**Subject: Canal Landing New Yard – Phase 1  
40 West Commercial Street  
Applicant: New Yard, LLC  
Amended Site Plan Application**

**Subject: Permit # 201302298**  
**Canal Landing New Yard – Phase 1**  
**40 West Commercial Street**  
**Applicant: New Yard, LLC**  
**Height information and Flood Hazard Development Permit Application for New Tension Fabric Structure**

**Subject: Canal Landing New Yard – Phase 1  
40 West Commercial Street  
Applicant: New Yard, LLC  
Amended Site Plan Application- Responses to staff and peer review comments**

PROJECT: CANAL LANDING (PHASE 1A)  
 TITLE: FIRE PROTECTION PLAN PHASE 1A ONLY  
 CLIENT: NEW YARD LLC  
 58 FORE STREET  
 PORTLAND, ME 04101

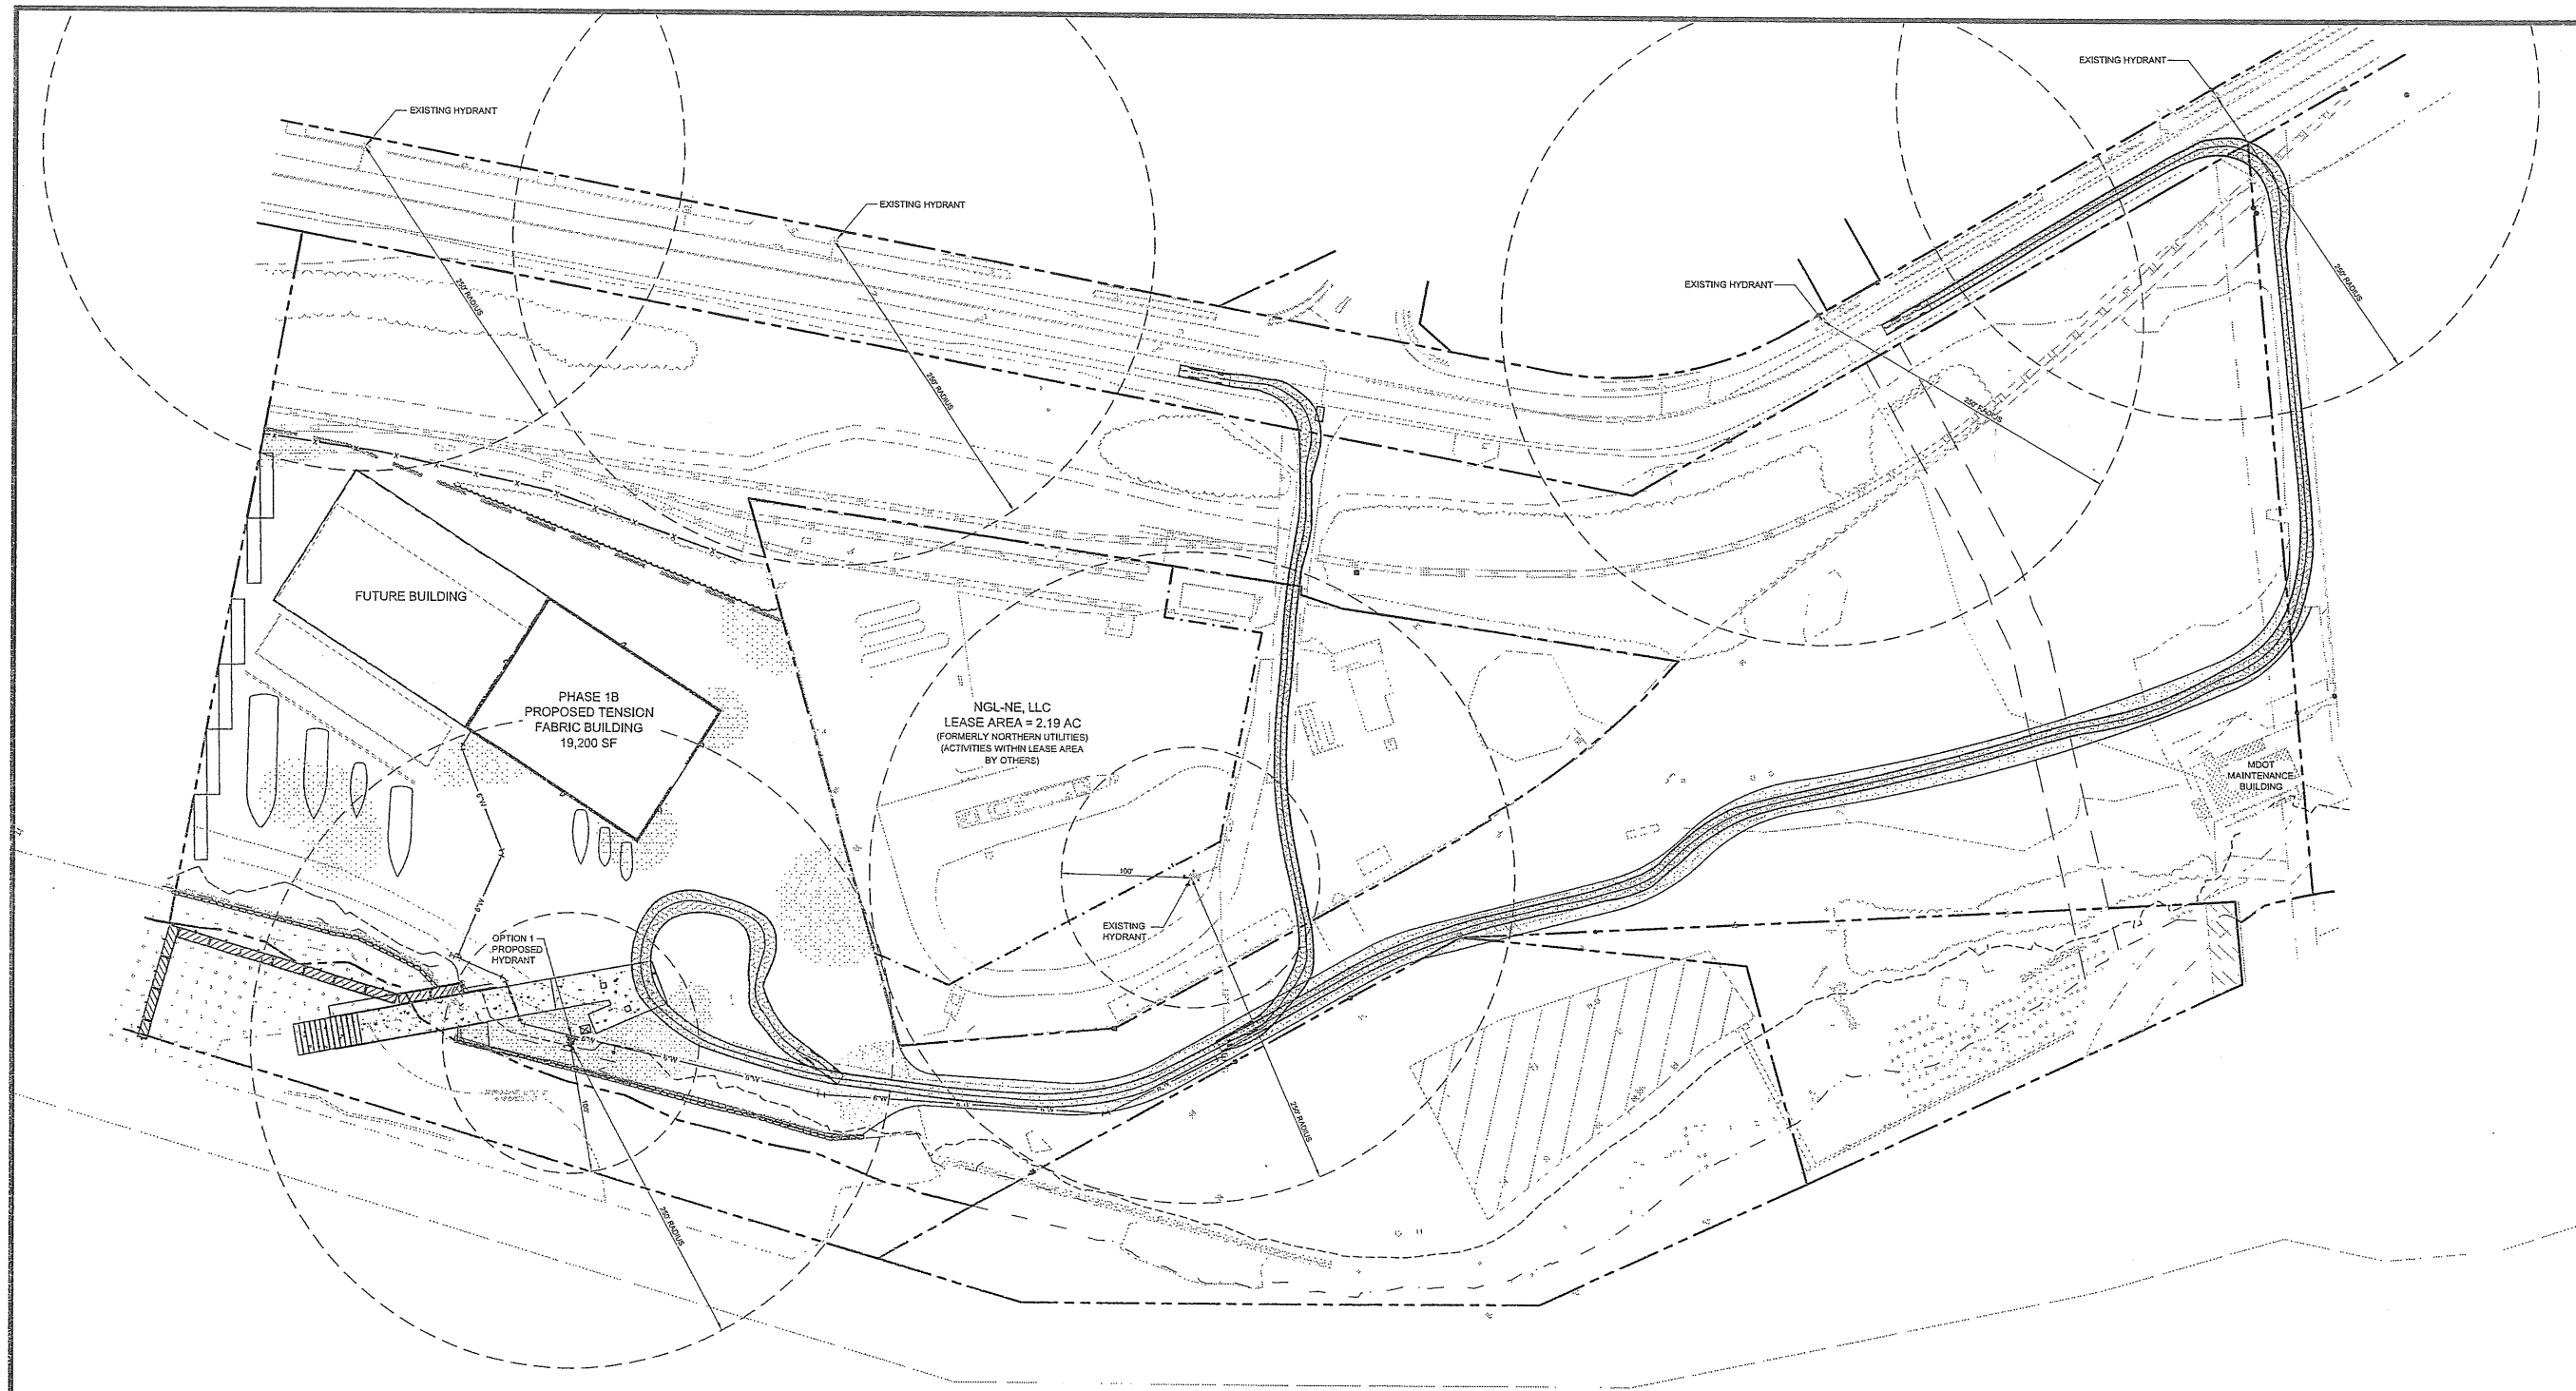
On behalf of New Yard, LLC (New Yard), we are responding to your email transmission dated October 10, 2013 that contained staff review comments related to the Amended Site Plan application. Specifically, you have requested an update to the proposed landscape plan as well as information pertaining to the Fire Safety compliance review. The peer review engineer also has requested additional information on Stormwater management. We offer the following for each of these informational requests.

3. In accordance with NFPA 1 we have provided a hydrant at the proposed boat ramp. This hydrant location will be within approximately 160 feet of the buildings fire department connections. NFPA 1 requires a hydrant must be located within 100 feet of the building fire department connections (and at least 40 ft. away from the buildings), so we have modified the plan to include an additional hydrant to meet this requirement. The accompanying Figure 1 depicts the additional hydrant location. The final plans to be submitted as part of the Performance Guarantee will include this additional hydrant.

4. NFPA 1 requires that any portion of a building can be no more than 450 ft. from an access road, when the facility is fully protected by an automatic sprinkler system. This requirement is met with the proposed layout. NFPA 1 also requires that at least one exterior door for each building be within 50 ft. of an access roadway. This too is also met.

Proposed Tension Fabric Building #1 - Canal Landing

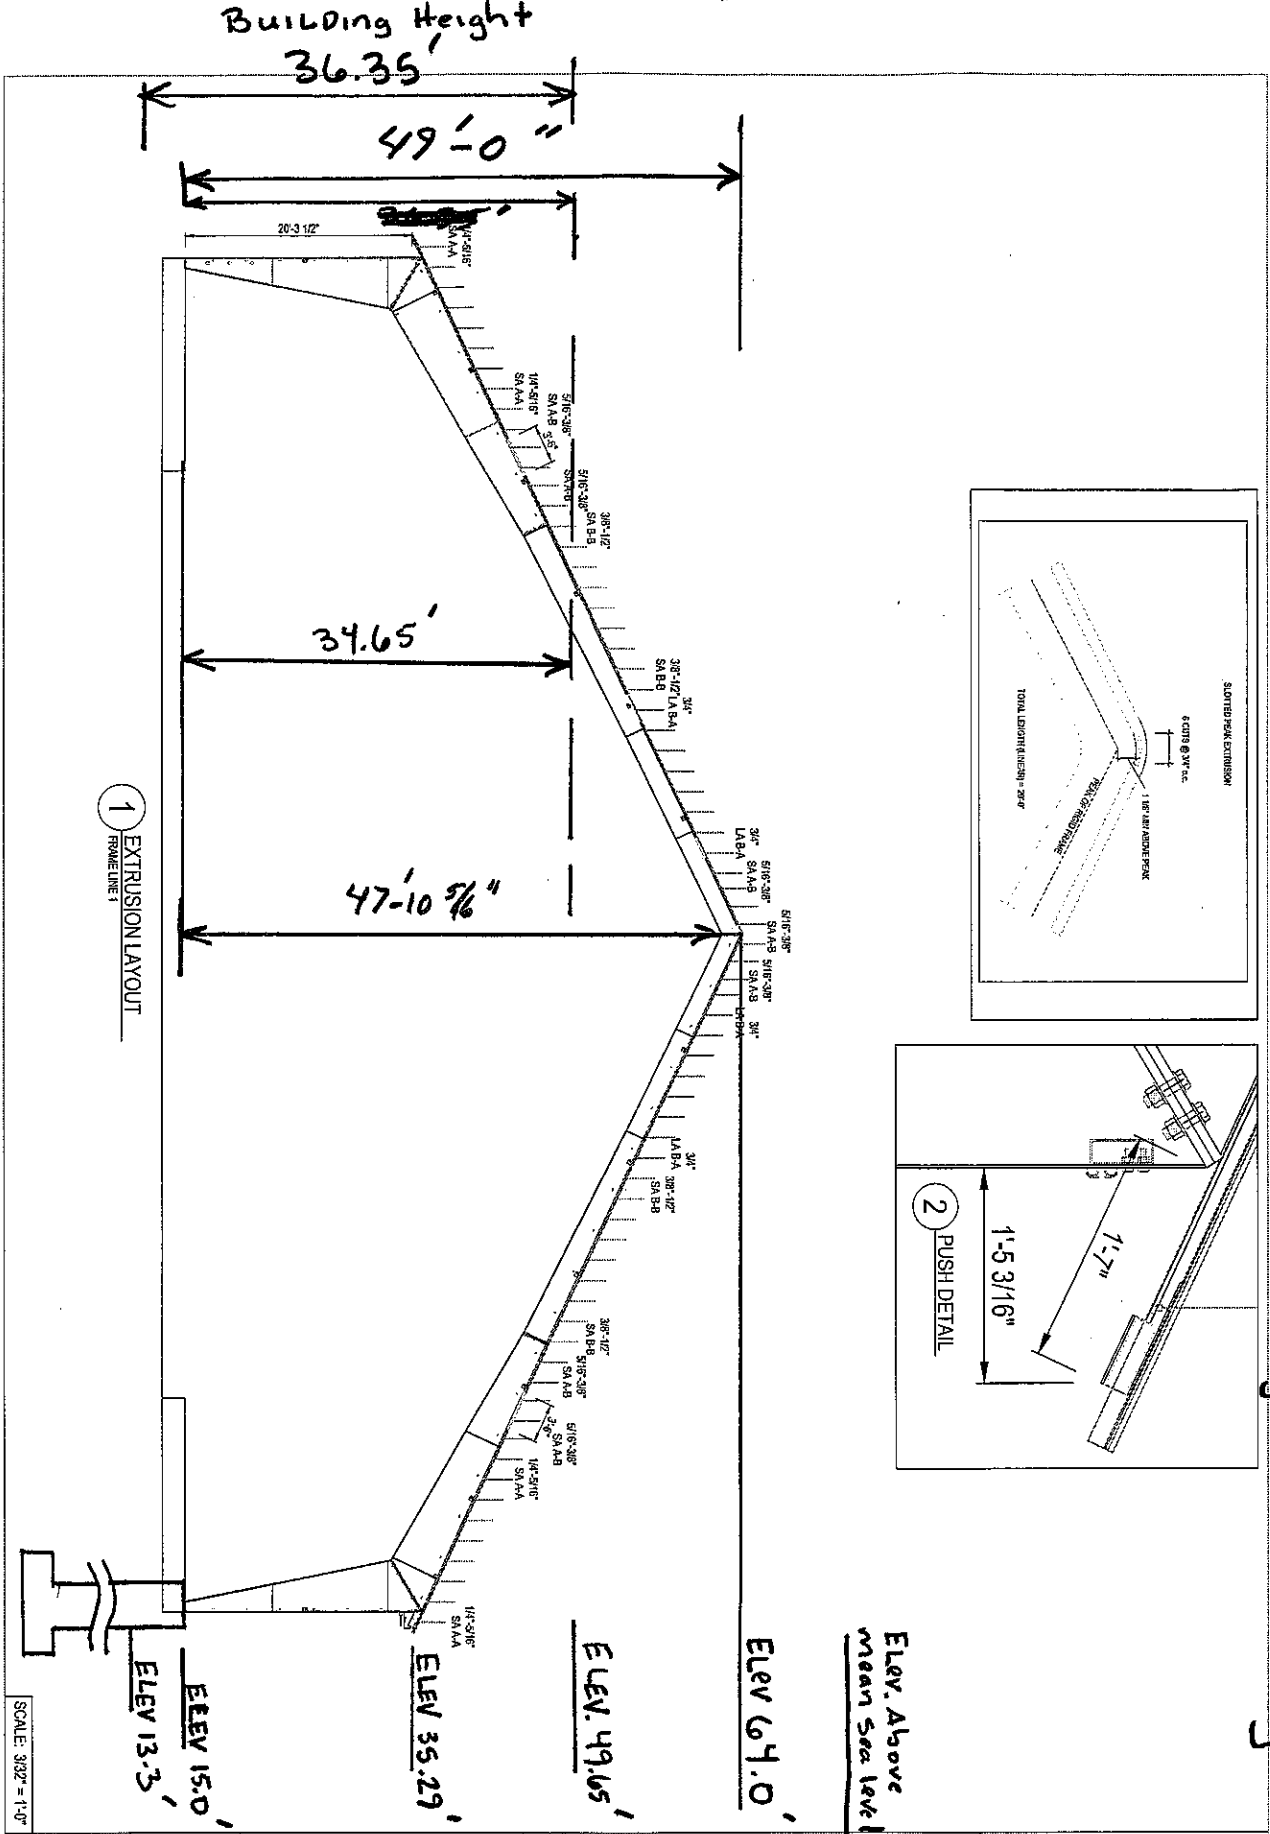
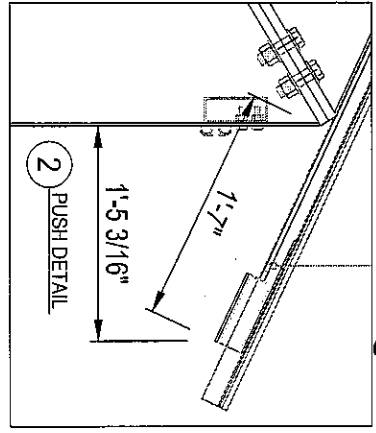
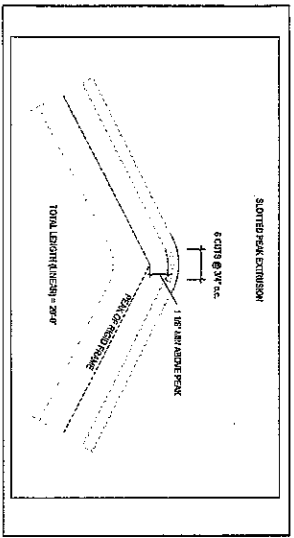
We have received your email transmission dated 10/10/2013 related to a request for additional building height information as well as the flood hazard development permit application for the proposed tension fabric structure at the New Yard, 40 West Commercial Street. Regarding the additional information related to the building height and compliance with the WPDZ code requirements we offer the following evidence:

**Conclusion: The dimensional building height as defined for pitched roofs is computed to be approximately 36.35' which is less than the maximum allowable building height in the WPDZ which is 45.0' therefore the proposed building is compliant. The accompanying figure 1 depicts the dimensional measurements and elevations used for these computations.**

1. The proposed building will be installed on a cast in place concrete foundation wall with a top elevation at 15.0' (NGVD29). The building eave dimensional height is 20'-3 1/2" (20.29') and the clear dimensional height is 47'-10 5/16" (47.86'). From top of foundation to roof peak the estimated overall dimensional height is approximately 49'.
2. In accordance with Section 14-47 of the Code of Ordinances the overall building height is defined as the vertical measurement to a midway point between the level of the eaves and the highest point of pitched roofs. For the proposed building this is measured as follows:

Step 1 Find midway point between eave height and top of structure or  
 $49.0' - 20.29' = 28.71'$  divided by 2  
 $= 14.36'$

Step 2 midway point dimensional height above top of foundation  
 $= 20.29' + 14.36' = 34.65'$  (or elevation 49.65')

Step 3 Compute building height over average existing ground grade around building perimeter. In accordance with Section 14-47 of the Code of Ordinances the Average exterior grade around the building perimeter is computed to be approximately elevation 13.3' (see attached plan). The overall building height is measured as follows:

Average ground grade = elevation 13.3'

Elevation at midway point of pitched roof = elevation 49.65'

**Building height is computed as  $49.65' - 13.3' = 36.35'$**
